From: Sue Howell
Sent: 01 October 2018 12:16
To: Planning.Responses
Cc: Anita Gardner
Subject: RE: Planning Consultation on LU/155/18/DOC

Comment from Greenspace

Registered: 15-JUN-18
Site Address: Sunnymede Courtwick Lane Littlehampton
BN17 7PA

Description of Works: Approval of details reserved by condition imposed under LU/32/17/PL relating to conditions 7-surface water drainage & 8-landscape scheme.

AWSunnyCourtwick Landscp 02

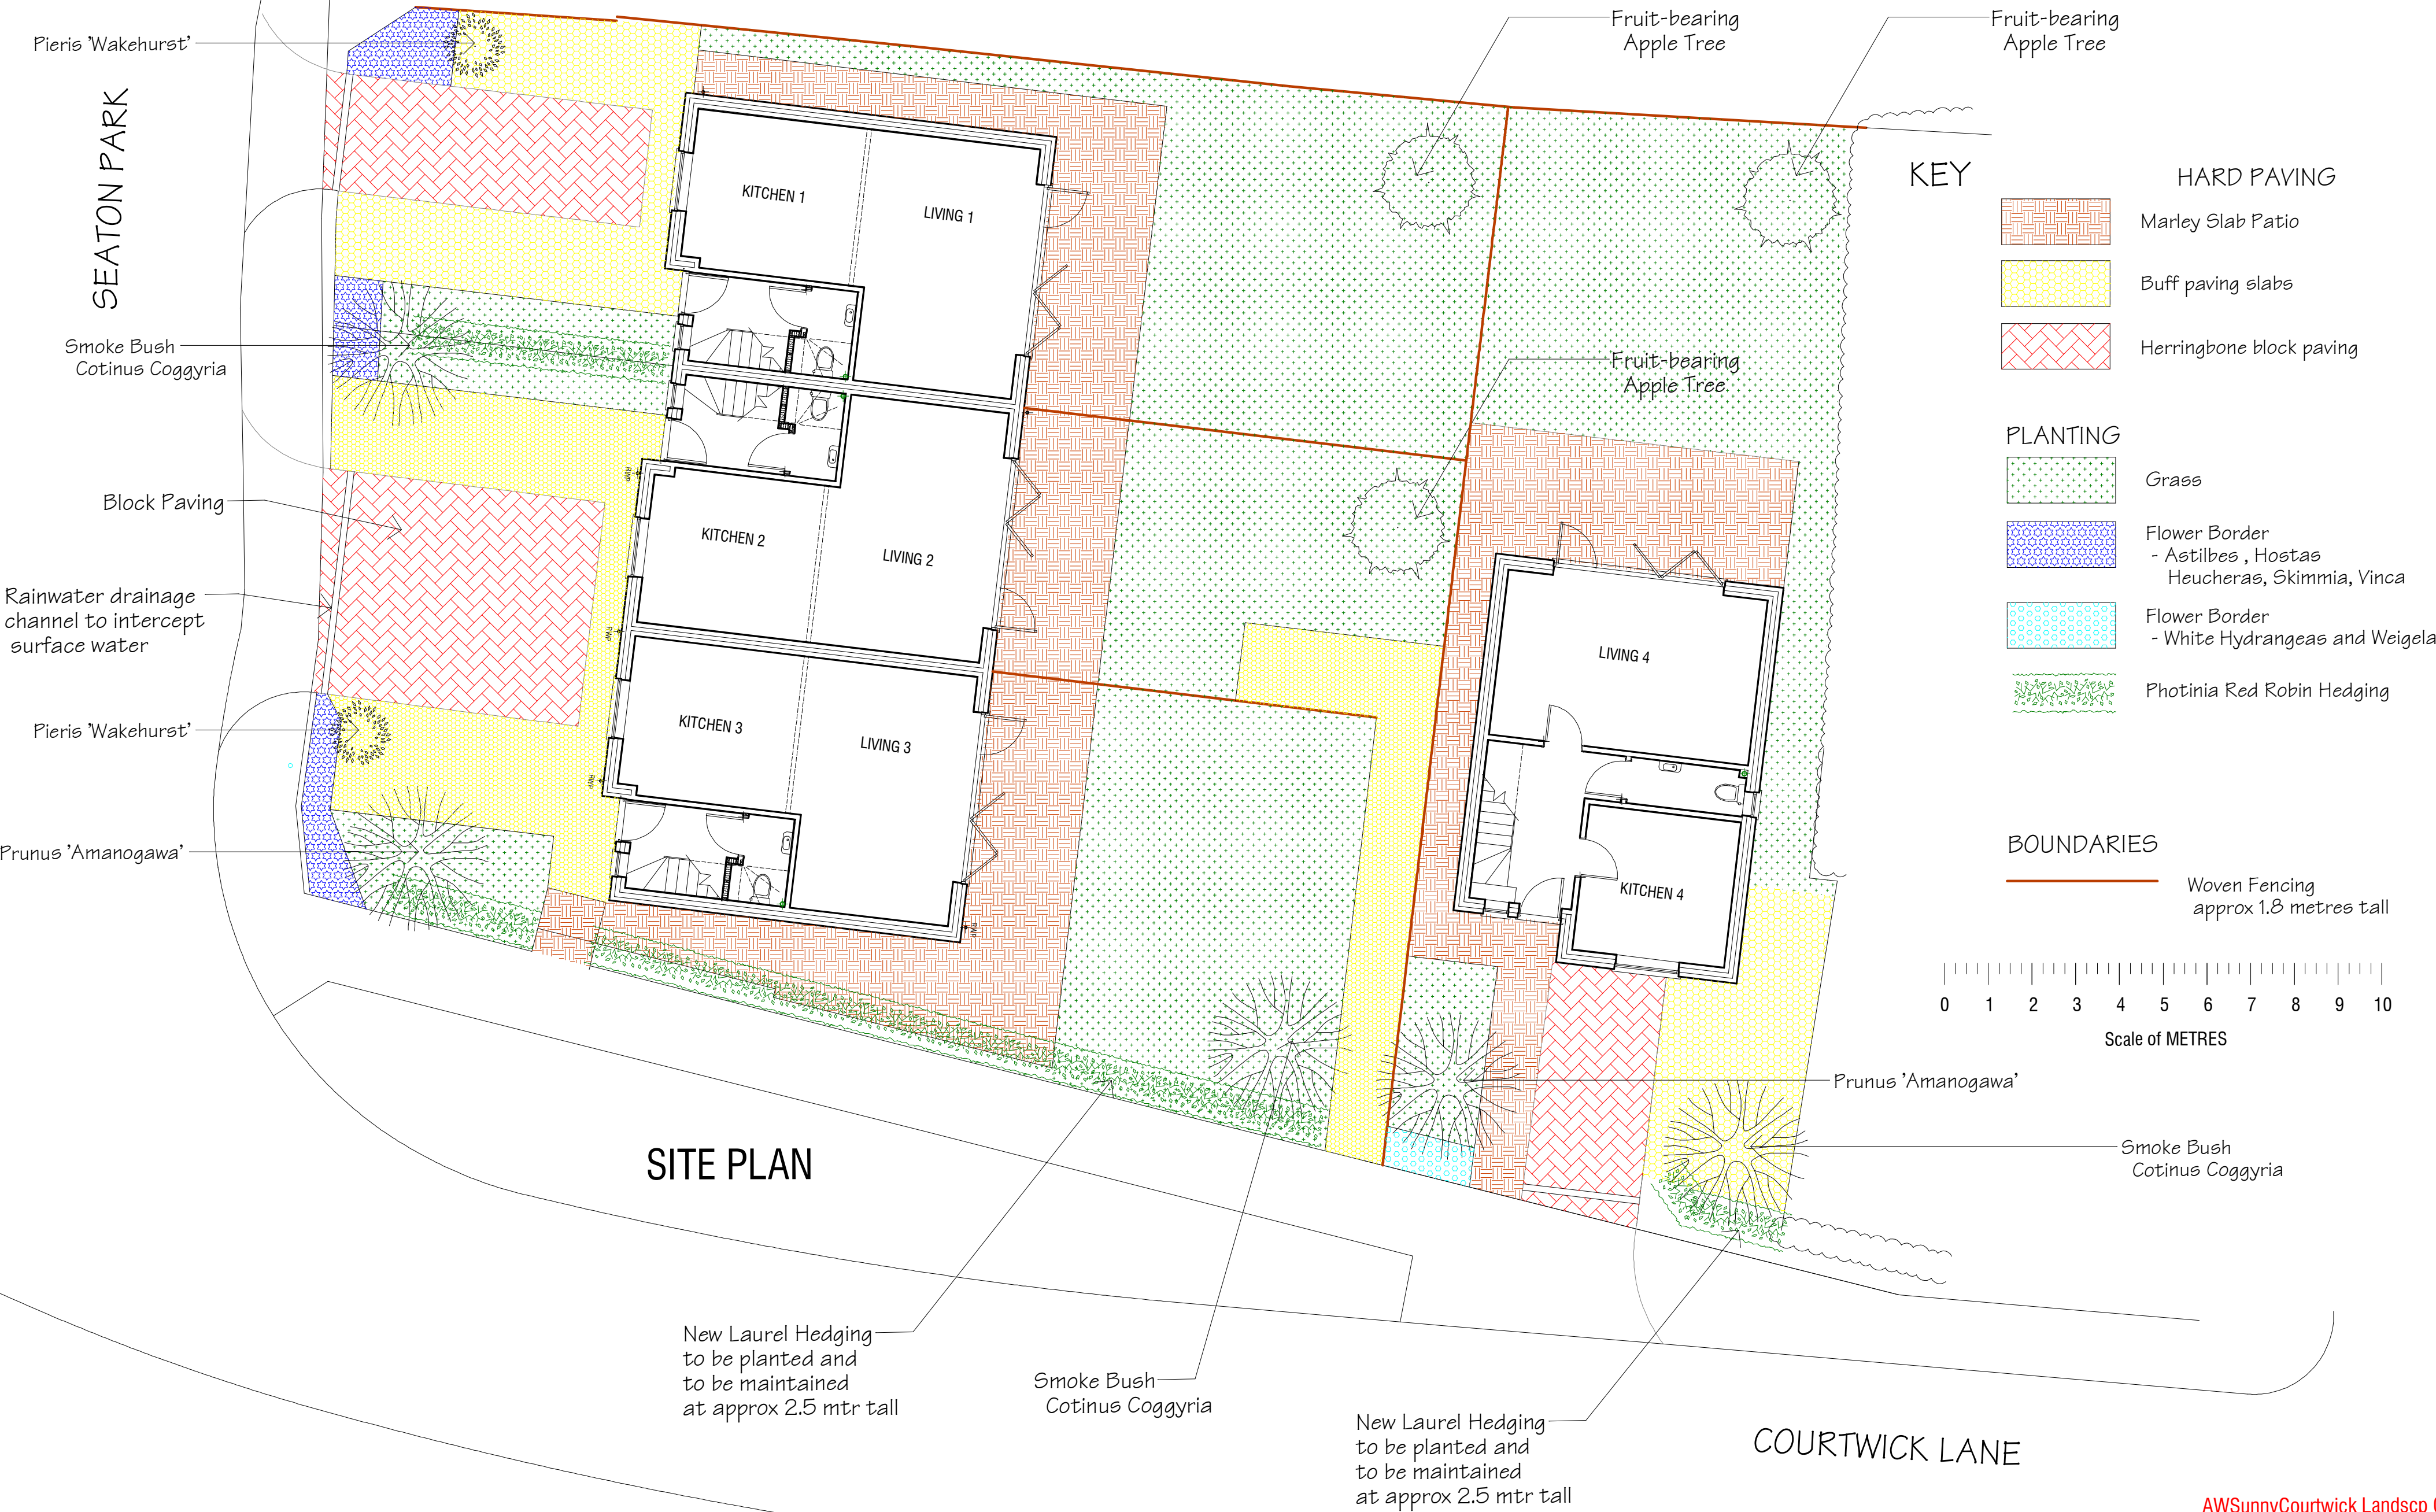
Further to submission of Hard and Soft landscape plan dwg AWSunny Courtwick landscp 02 and planting schedule, I can confirm that the information supplied does propose a scheme which is sufficiently detailed and fitting for location and therefore I would **recommend the discharge of Condition 8 Landscaping scheme** reserved under planning approval LU/32/17/PL on this application LU/155/18/DOC.
